Application for a non-material amendment following a grant of planning permission.

<input type="text" value="Erection of 1no. detached dwelling following demolition of motor repair garage."/>	
Reference number:	<input type="text" value="17/02885/FUL"/>
Date of decision	<input type="text" value="05/10/2018"/>

Additional roof window over bathroom on second floor.

ROOF PLAN

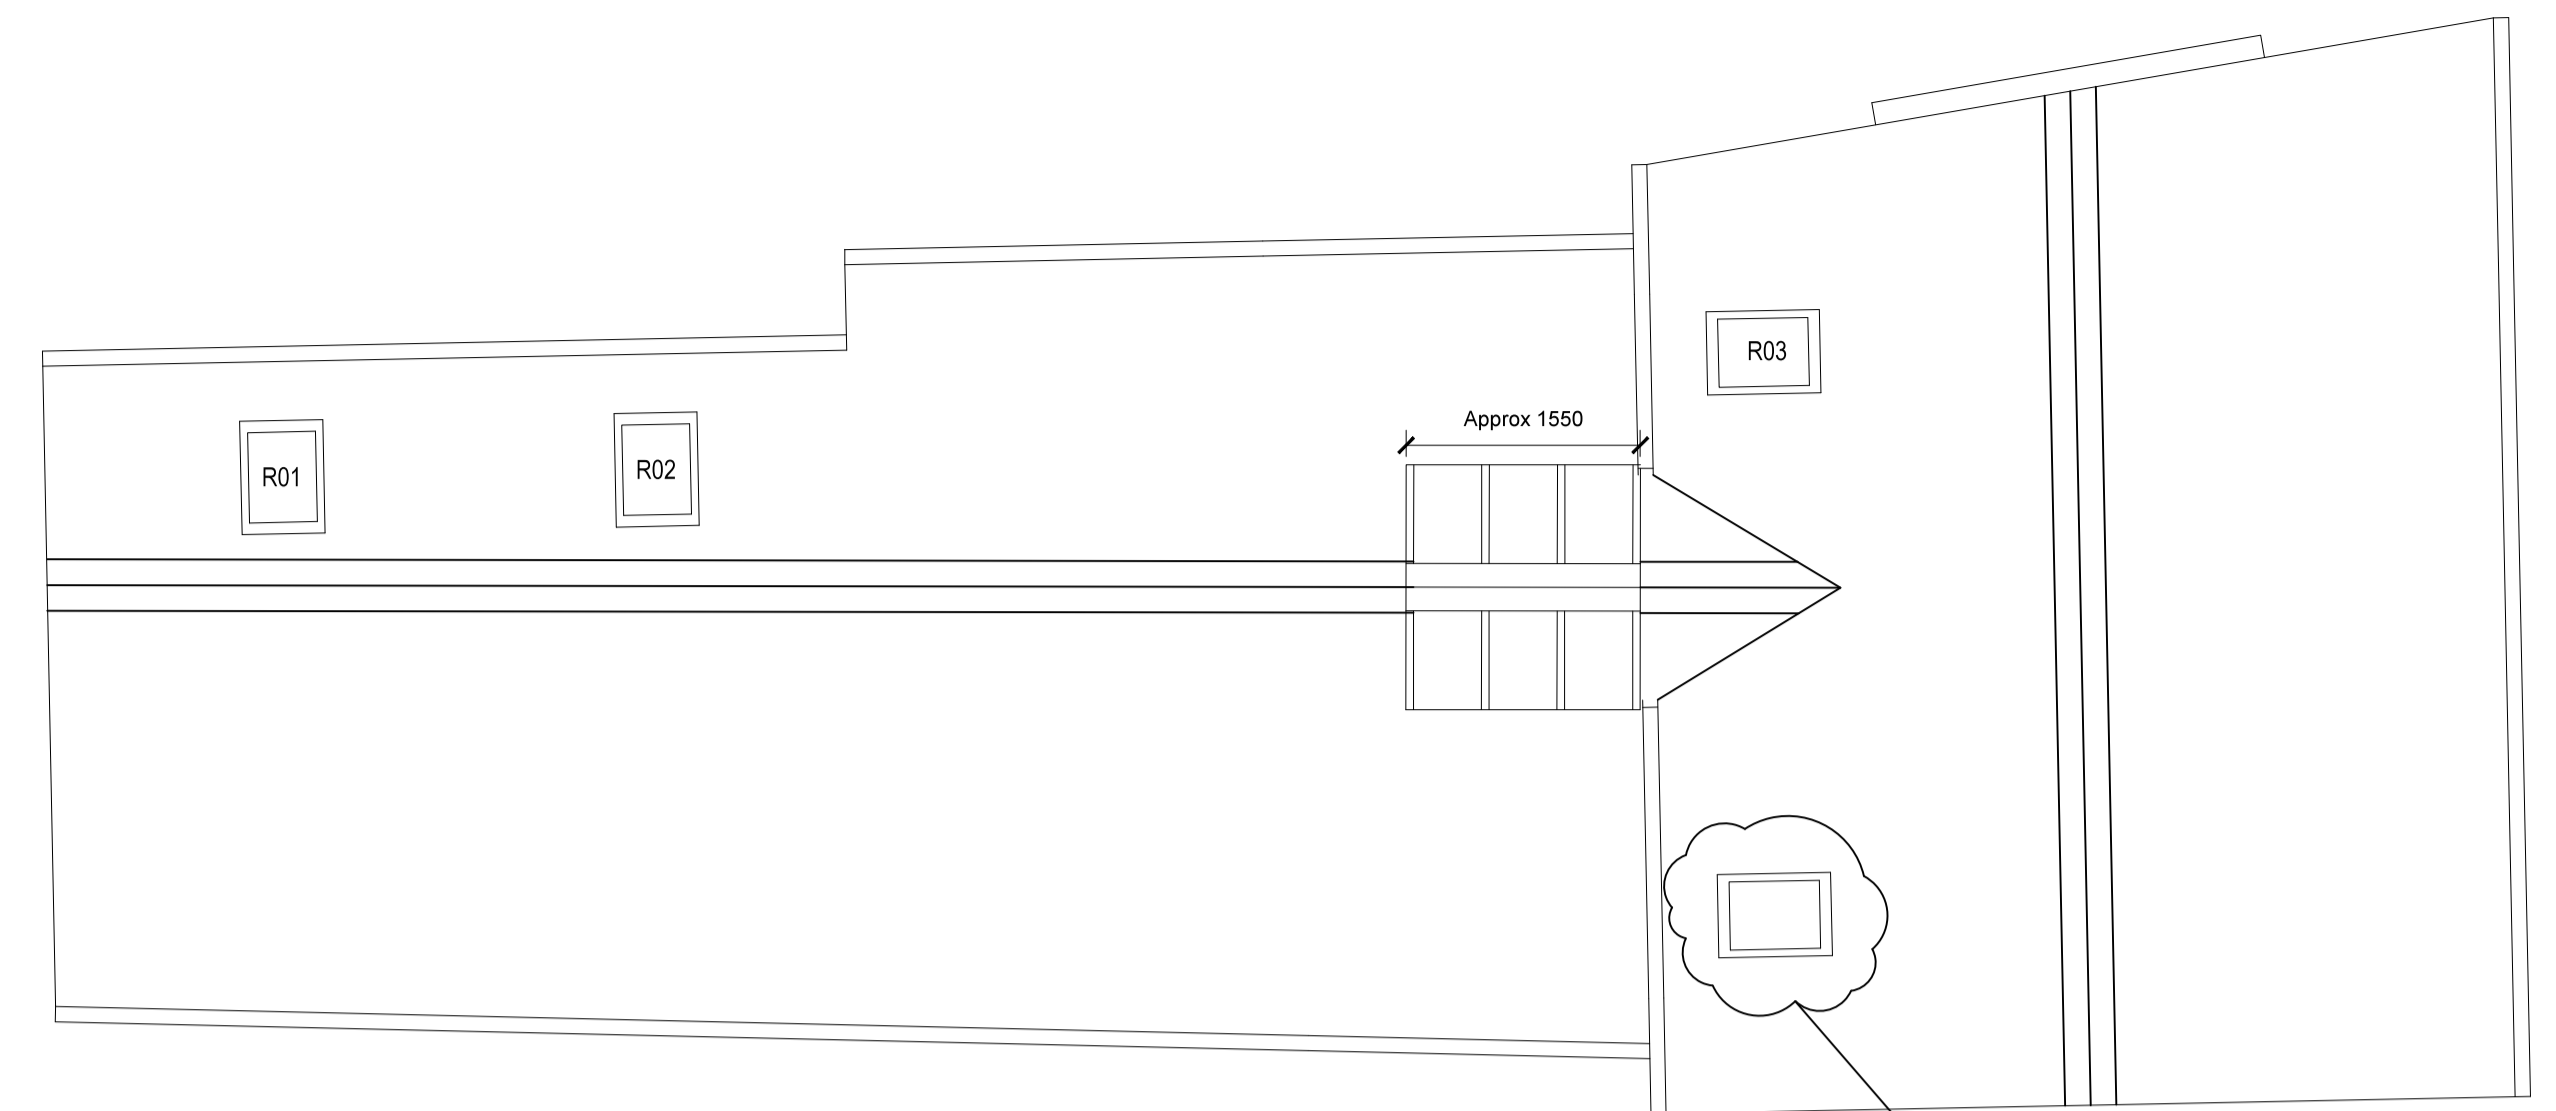
Provide natural light into the 2nd floor bathroom.
